RE: PENRITH HEALTH CAMPUS REDEVELOPMENT - ACCESSIBILITY ISSUES v2

Please find preliminary accessibility issues report with specific regards to the Penrith Health East Block level 1 and ICU level 2 Option 10.

Drawing
EB-SK 100
East Block Plan - Level 1
Draft Scheme Design

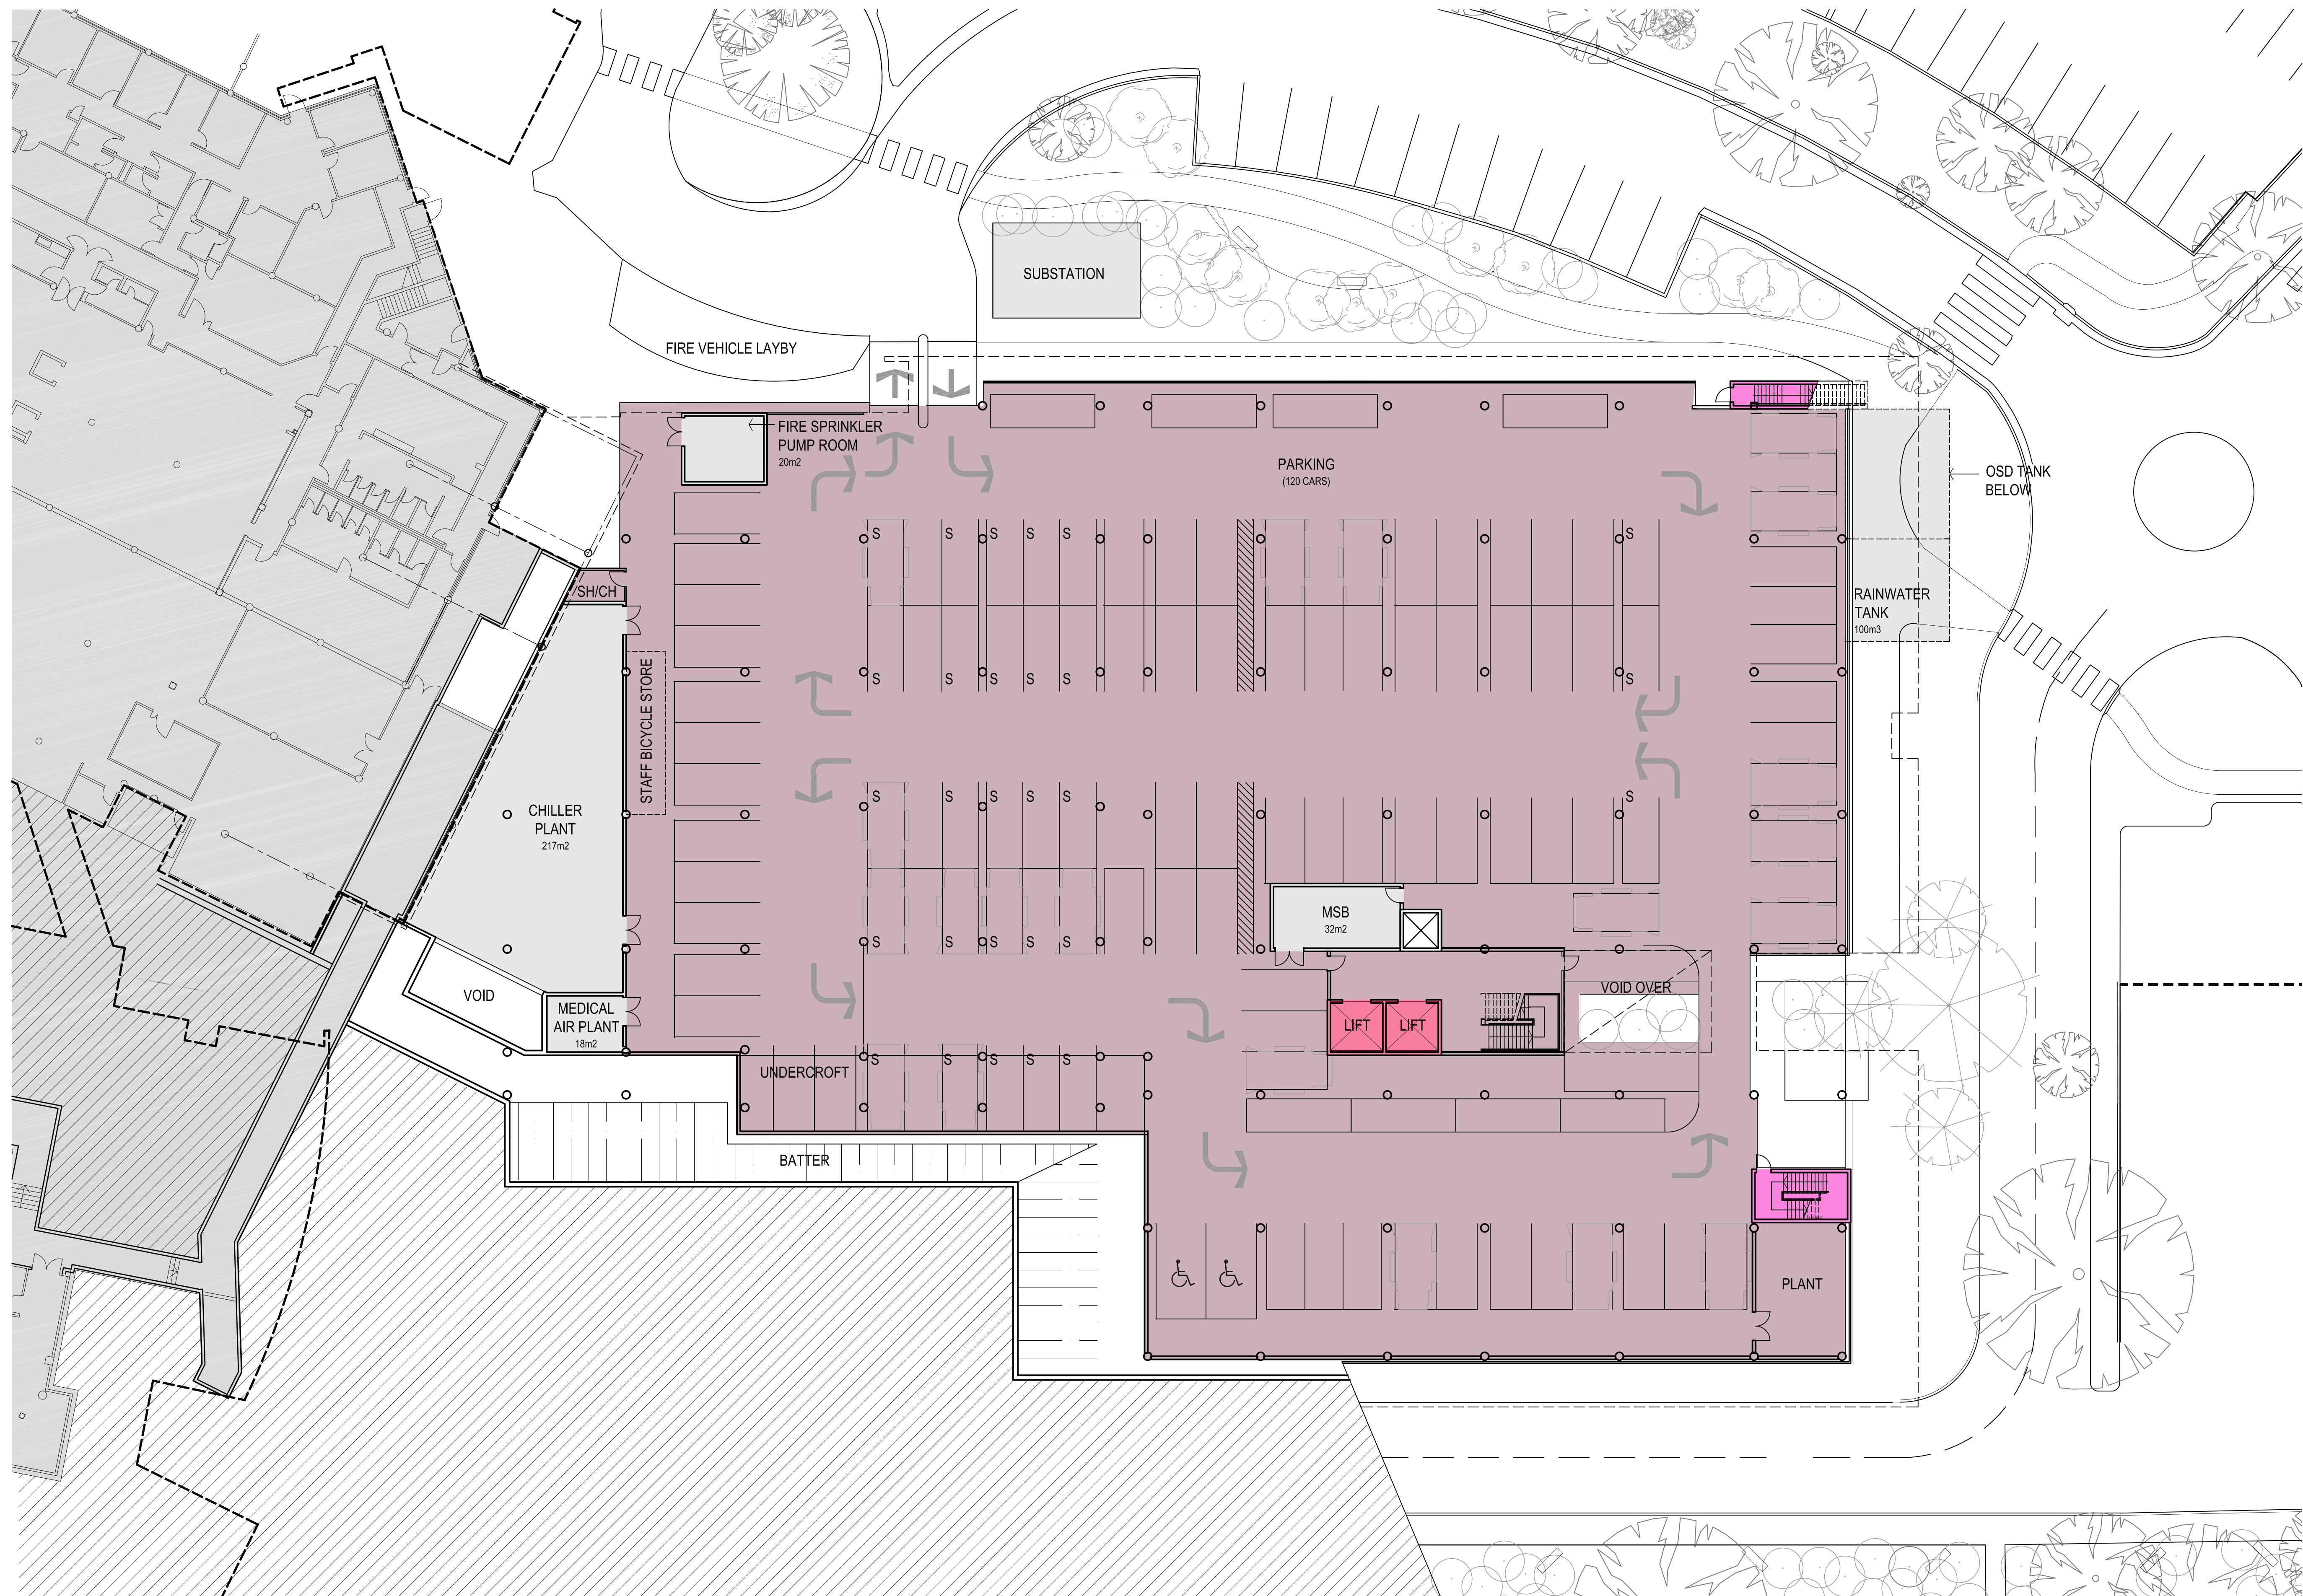
- iv) Provide kerb ramp at drop off in front of entry (level 2)
- v) All office and meeting room doors to have 800mm clear width (870mm door leaf)
- vi) Level 2 corridor door adjacent room 11 to have 470mm latch side clearance
- vii) Level 2 control room door to have 470mm latch side clearance
- viii) Level 2 doors leading into rooms 9 and 10 (from set up area) should have 220mm latch side clearance
- ix) Level 2 EDO accessible WC shall have a minimum 2000mm x 2000mm internal dimension compliant with AS1428.1
- x) Level 2 O/P accessible WC has a minimum 2500mm x 1600mm internal dimensions to comply with AS1428.1

Drawing
EB-SK 101
East Block Plan - Level 2
Draft Scheme Design

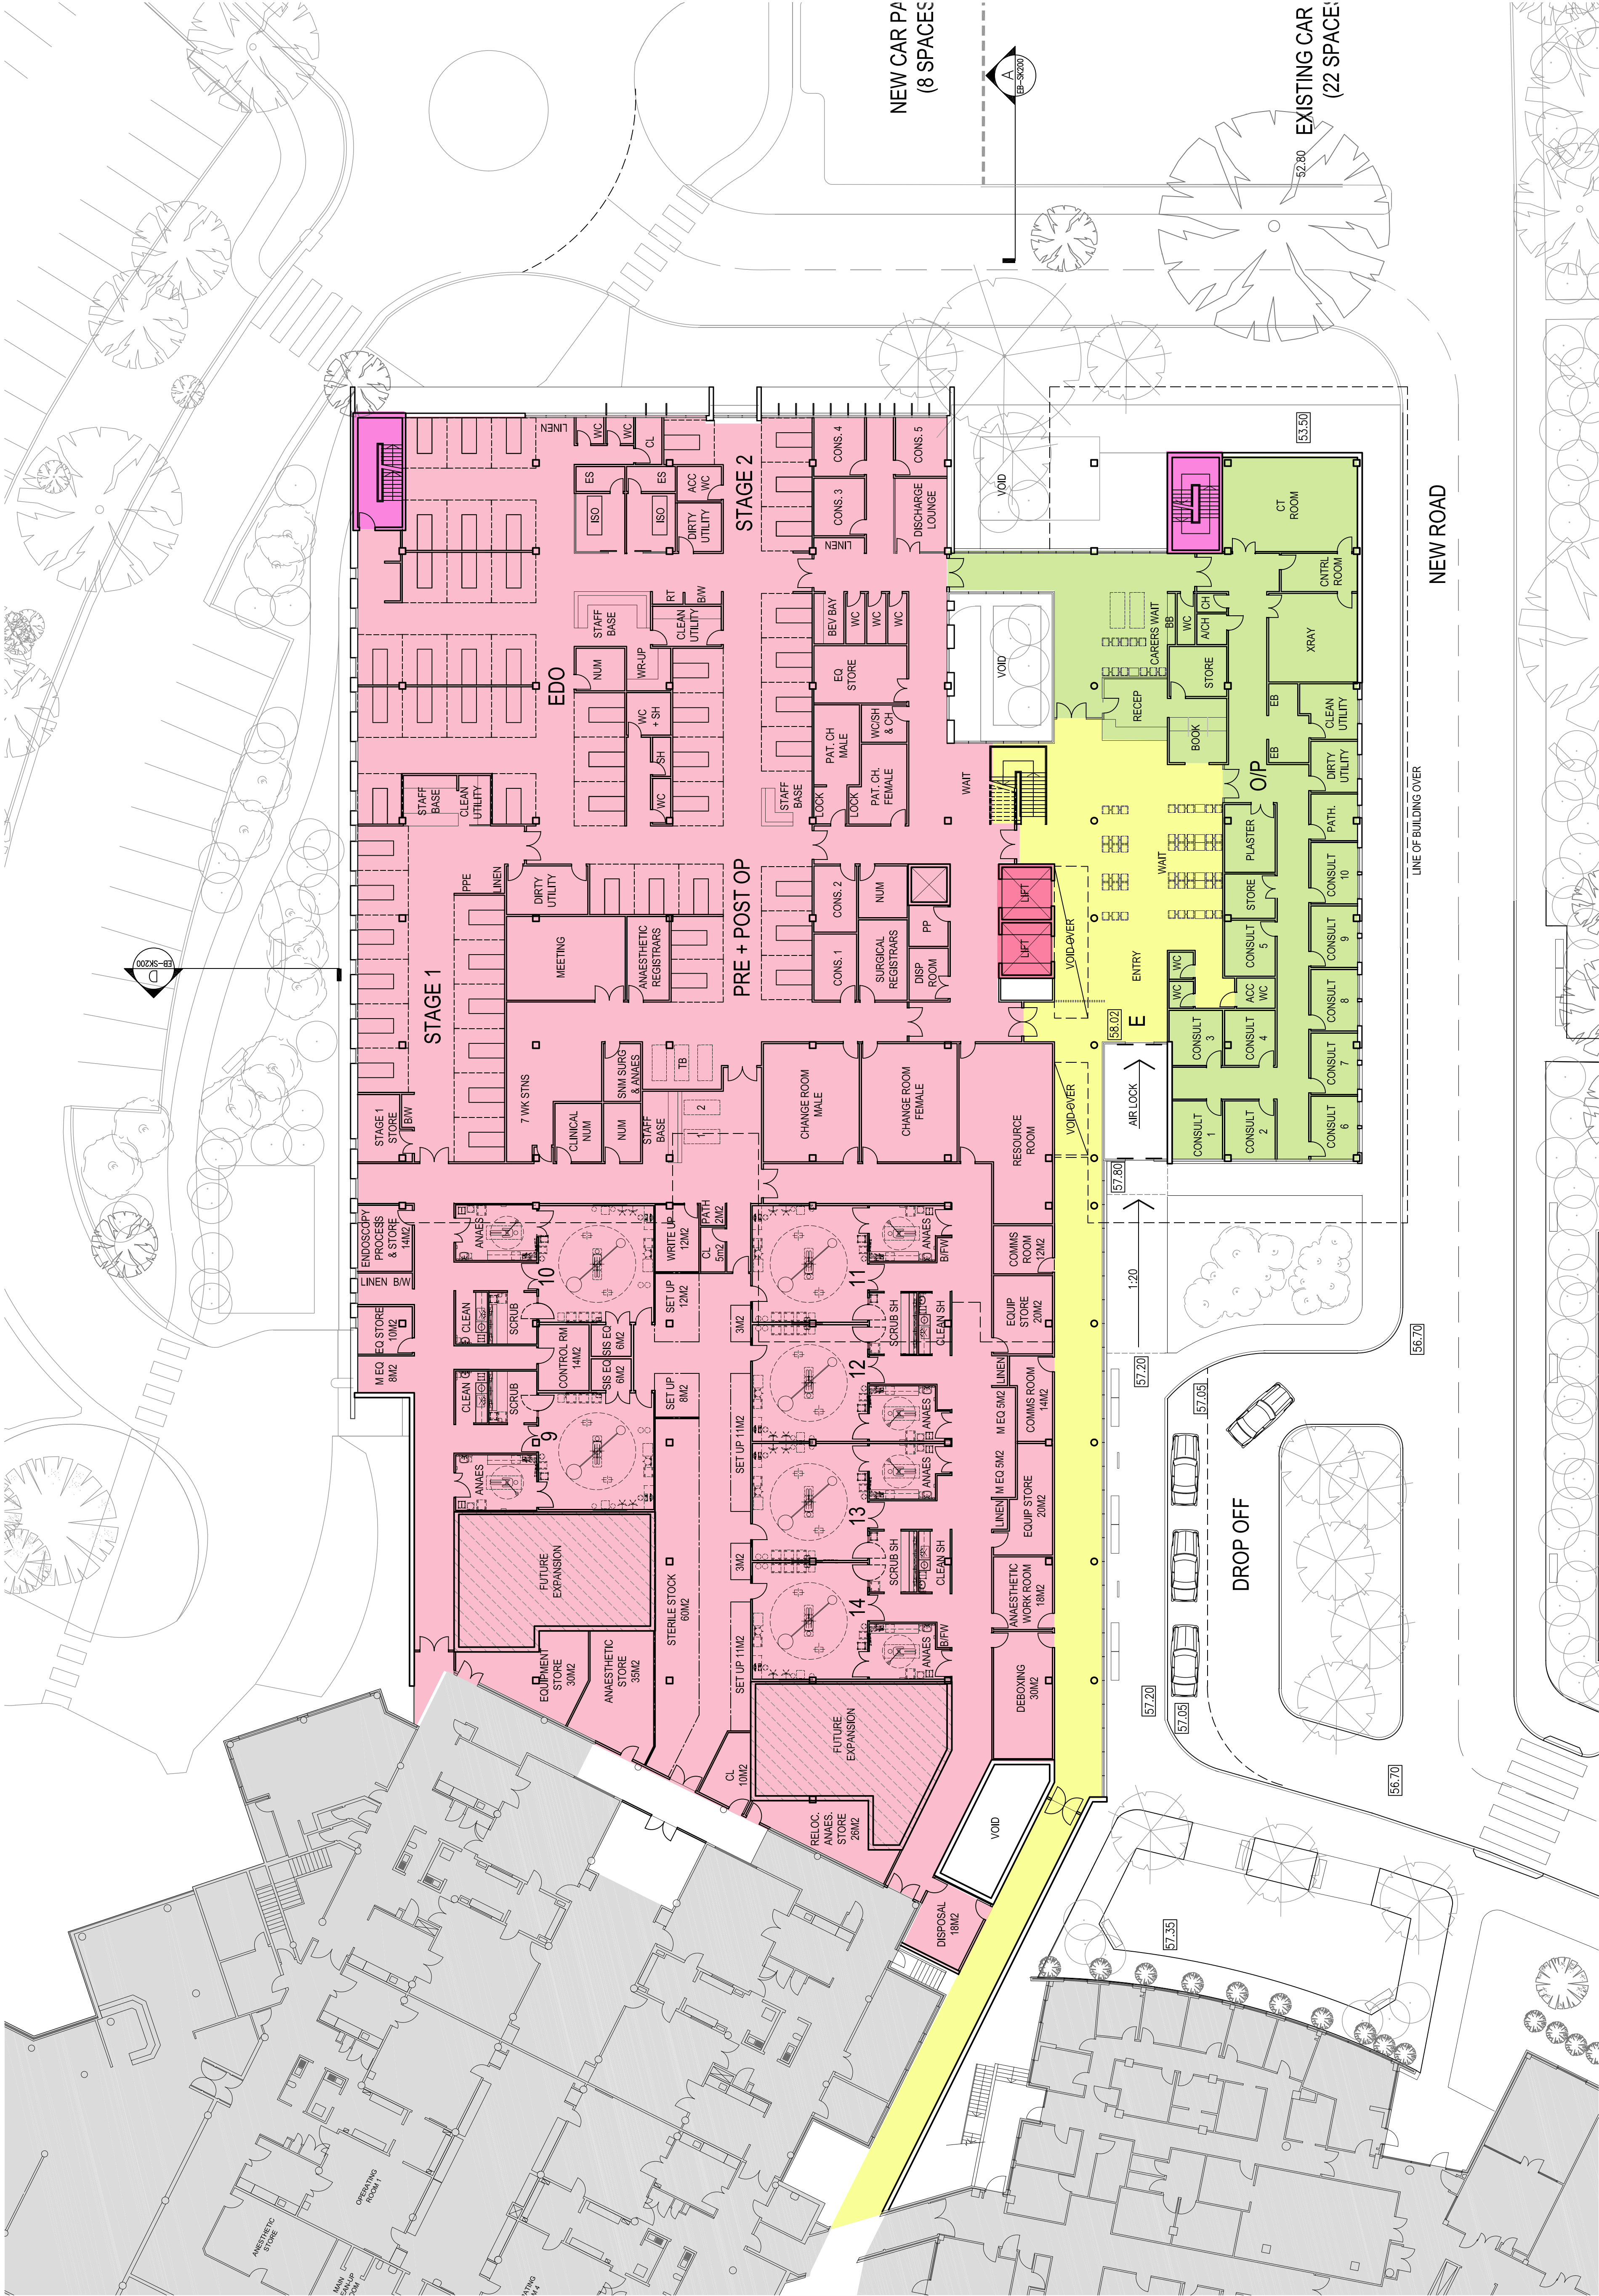
- iv) Ensure East Block level 2 O/P accessible WC has a minimum 2400mm x 2400mm or 2800mm x 1900mm internal dimensions to comply with AS1428.2
- v) East Block level 2 (A/CH) shall have a minimum 2070mm x 1540mm internal dimension to allow a wheelchair user to turn 180° (currently 1800mm x 1800mm).

- vi) East Block level 2 EDO WC/SH& CH shall have an internal dimension that would allow 1400mm x 1600mm unobstructed circulation space outside the shower, and 2070mm x 1540mm change area. The wash basin to site outside these areas.
